# CITY OF ALBUQUERQUE

RE: **ABQ Ride Daytona Transit Facility**  
**Grading and Drainage Plan (Engineer's Stamp Date: 6/14/17)**  
**Coversheet Stamp Date: 6/1/17**  
**Hydrology File: J09D025**

Based on the information provided in your submittal received on 6/23/17, the Grading and Drainage Plan cannot be approved for Building Permit until the following comments are addressed:

CITY OF ALBUQUERQUE TRANSIT DEPARTMENT ABQ RIDE ABQ RIDE DAYTONA DESIGN	
WALL PLAN & PROFILE	
DESIGN REVIEW COMMITTEE	CITY ENGINEER APPROVAL
City Project No. 60A 5658.05	Zone Map No. J-09-Z
Sheet S1

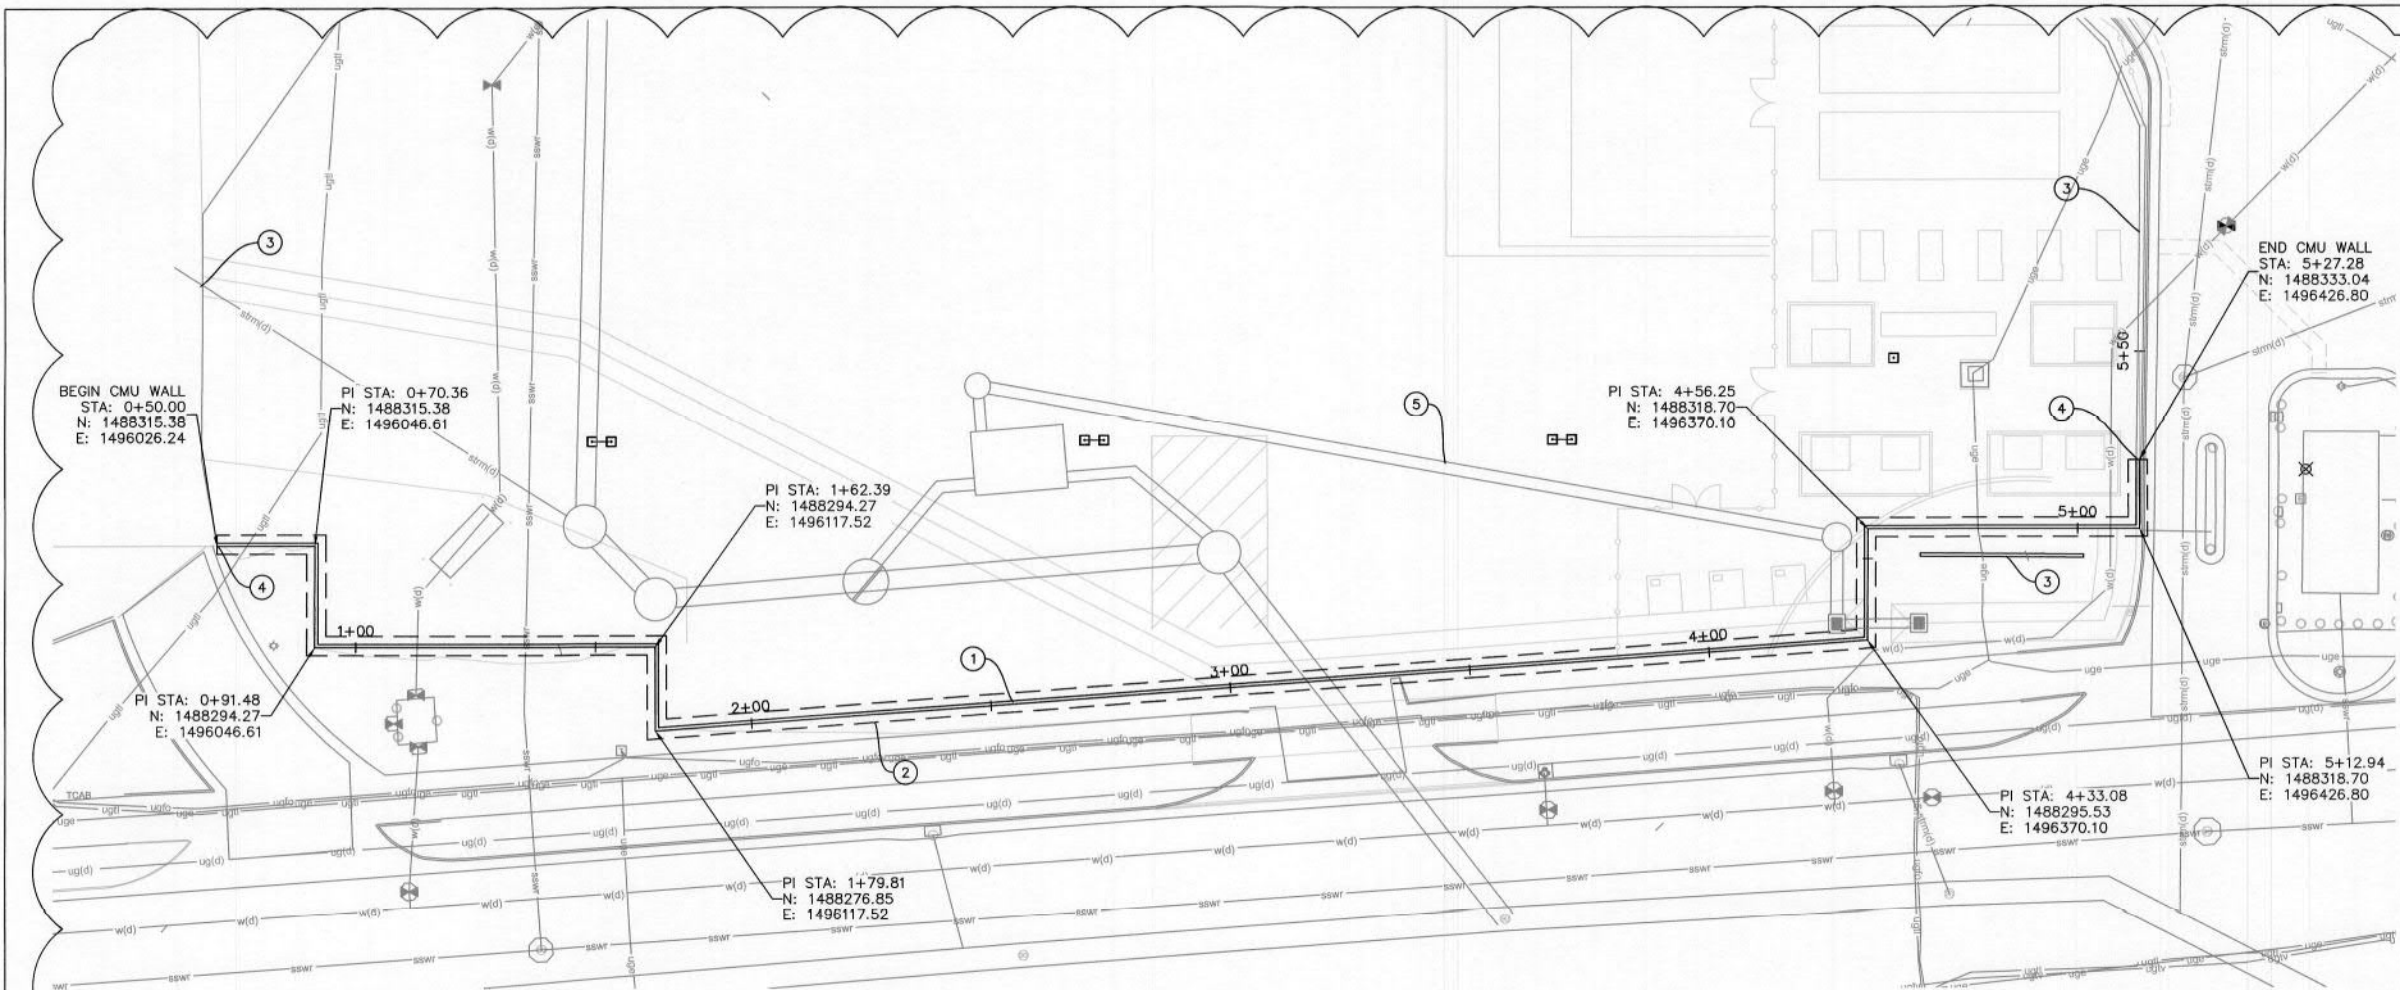
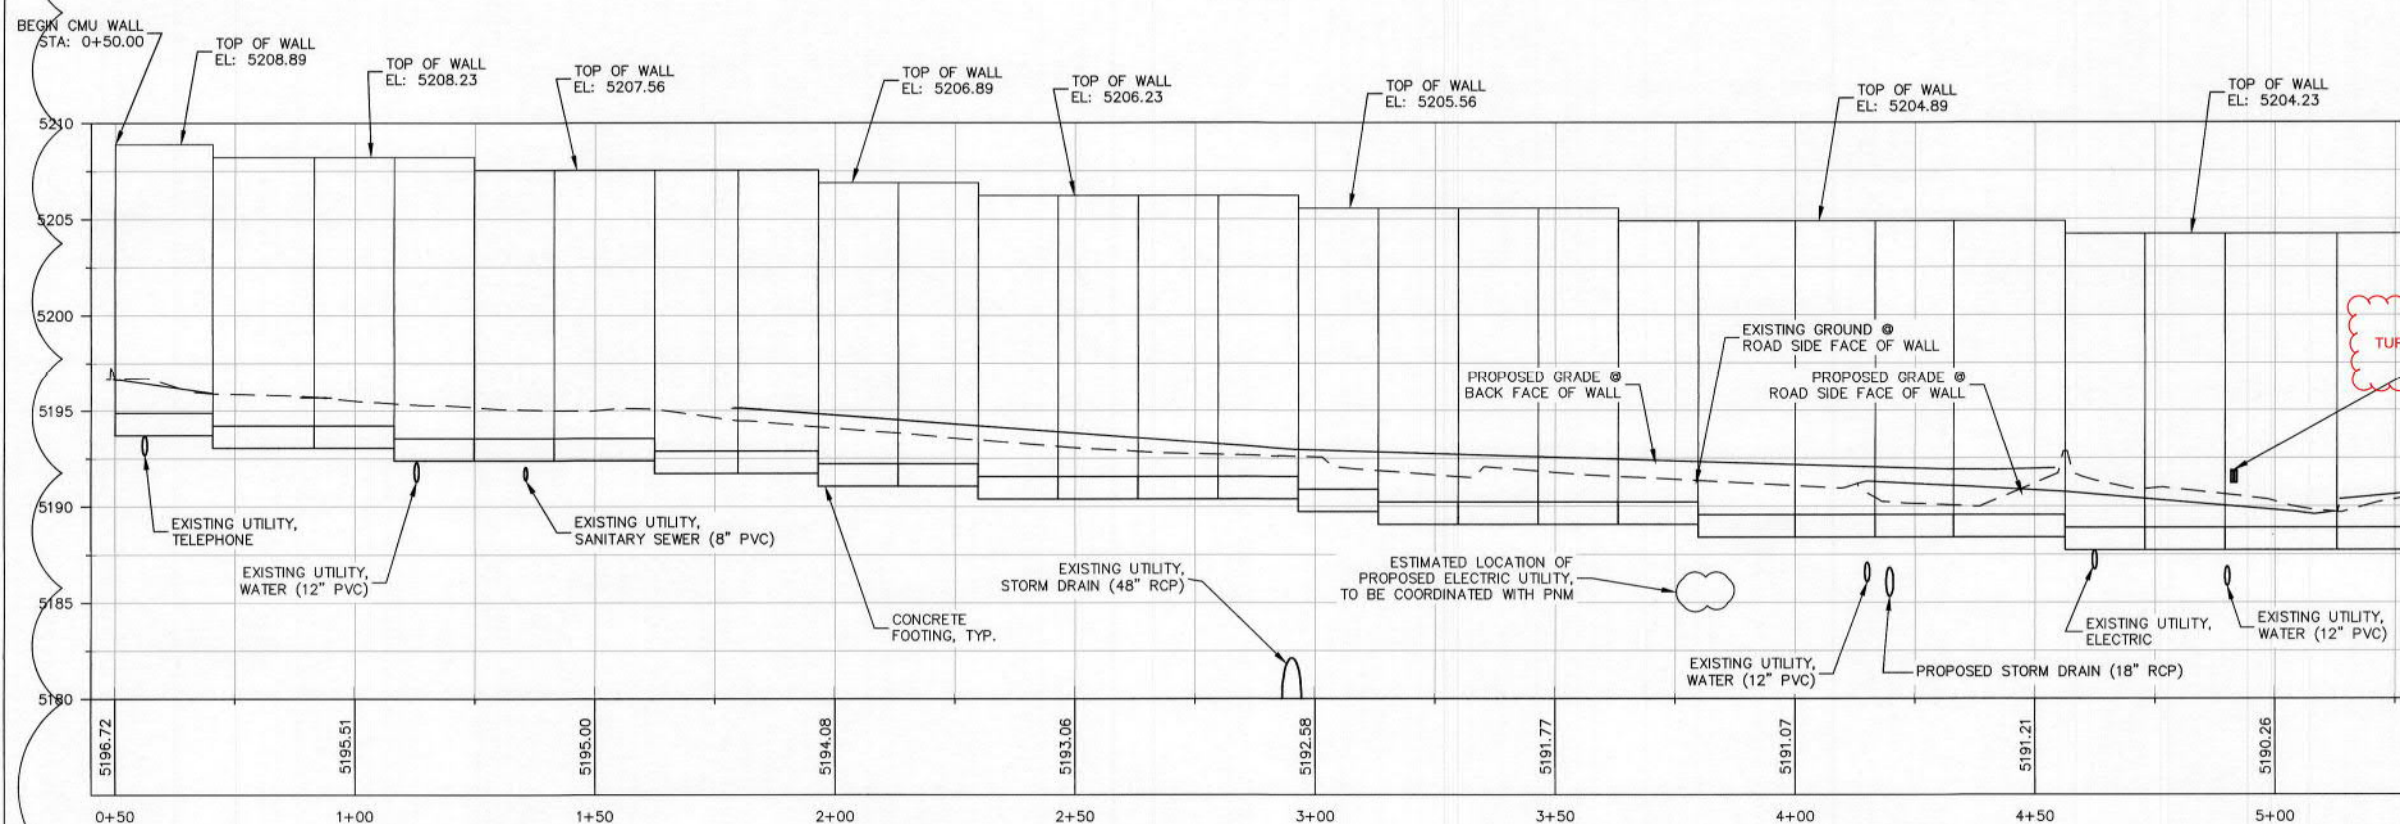
2. Include wall details. Specifically, it is unclear if the wall will contain flows along the southern edge of the parking lot where the valley gutter is running adjacent. Also, it appears a turned block or drain line is needed to pass flows through the wall at the southeast corner to get to the valley gutter on the other side.

**STC 16000s Precast Concrete Stormceptor®
(16000 U.S. Gallon Capacity)**

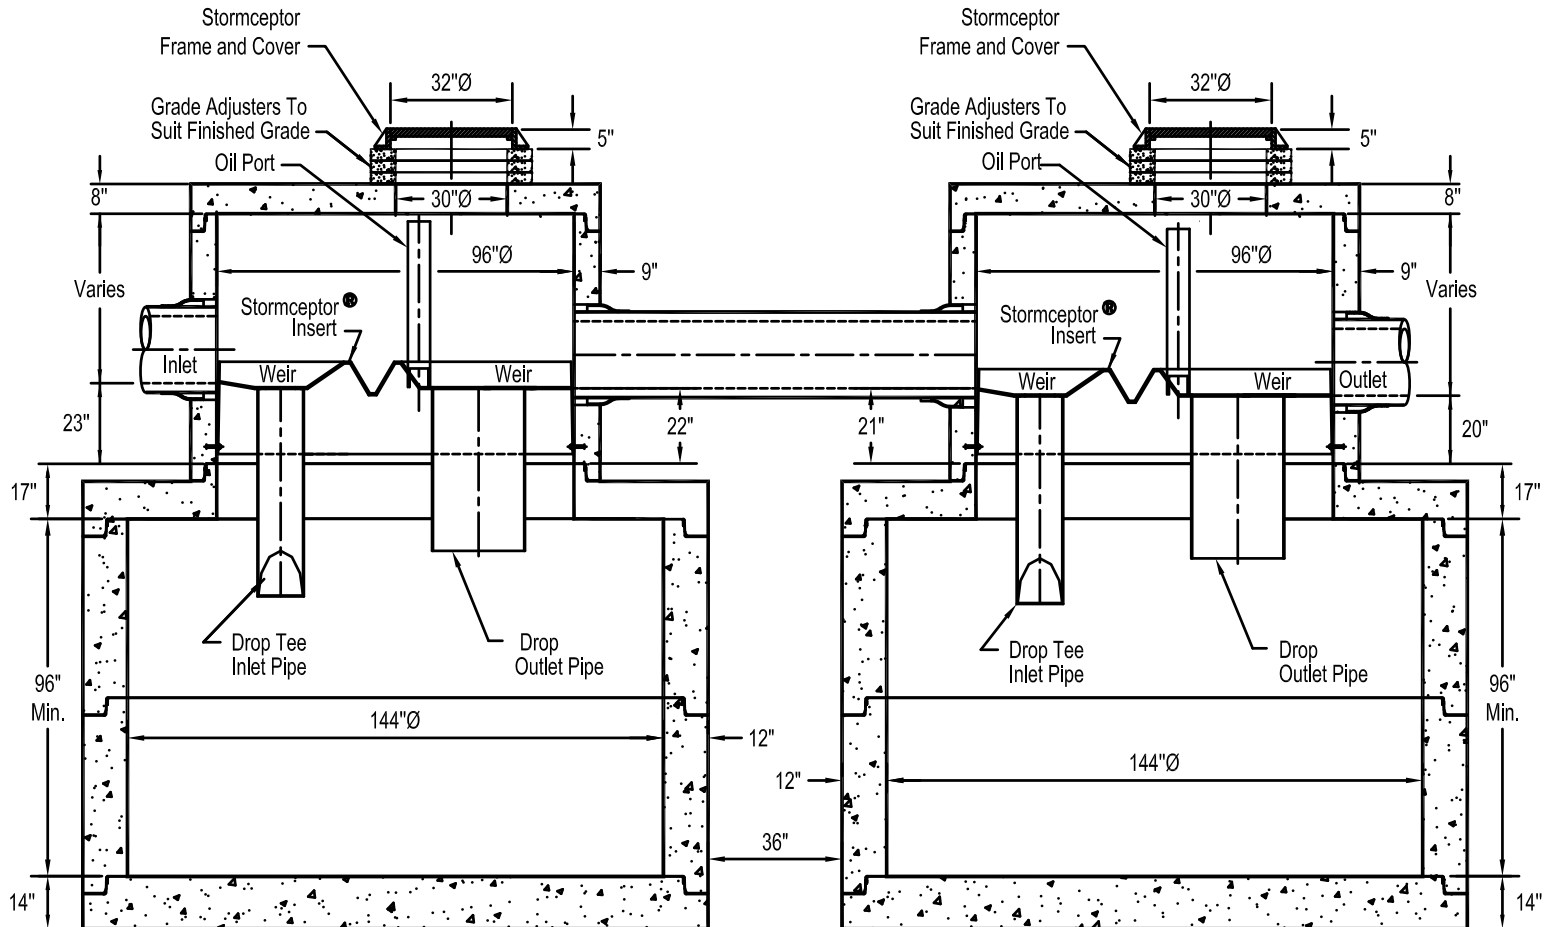
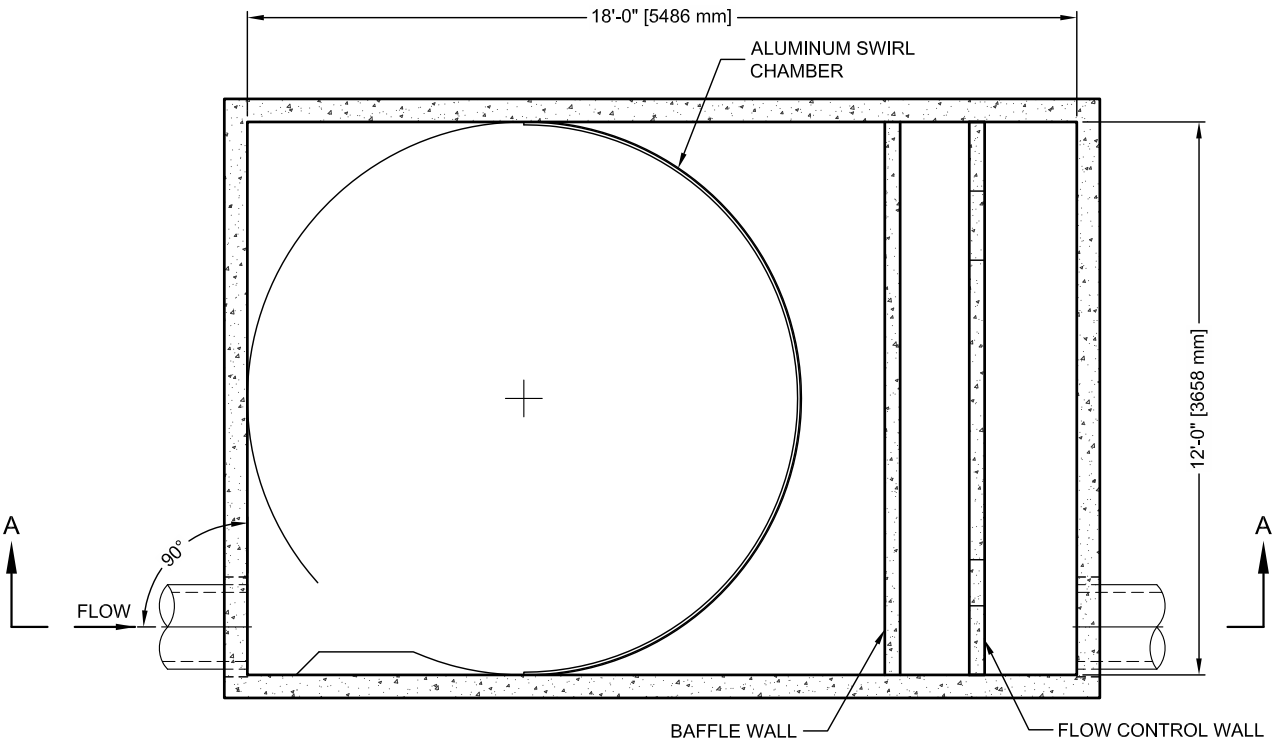
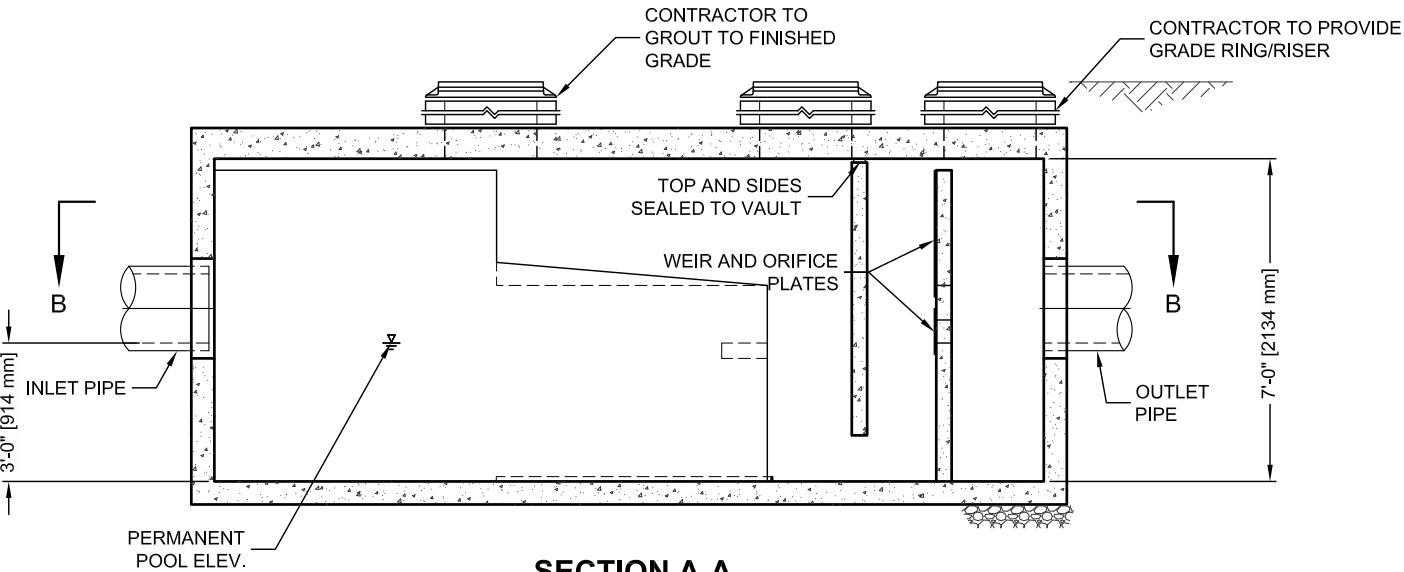
4. Is the 25cfs rating on the Stormwater Treatment System sufficient to treat the Q100 or the first flush volume? The SPCC plan should govern its sizing. Please provide a typical detail for the Stormwater Treatment System.
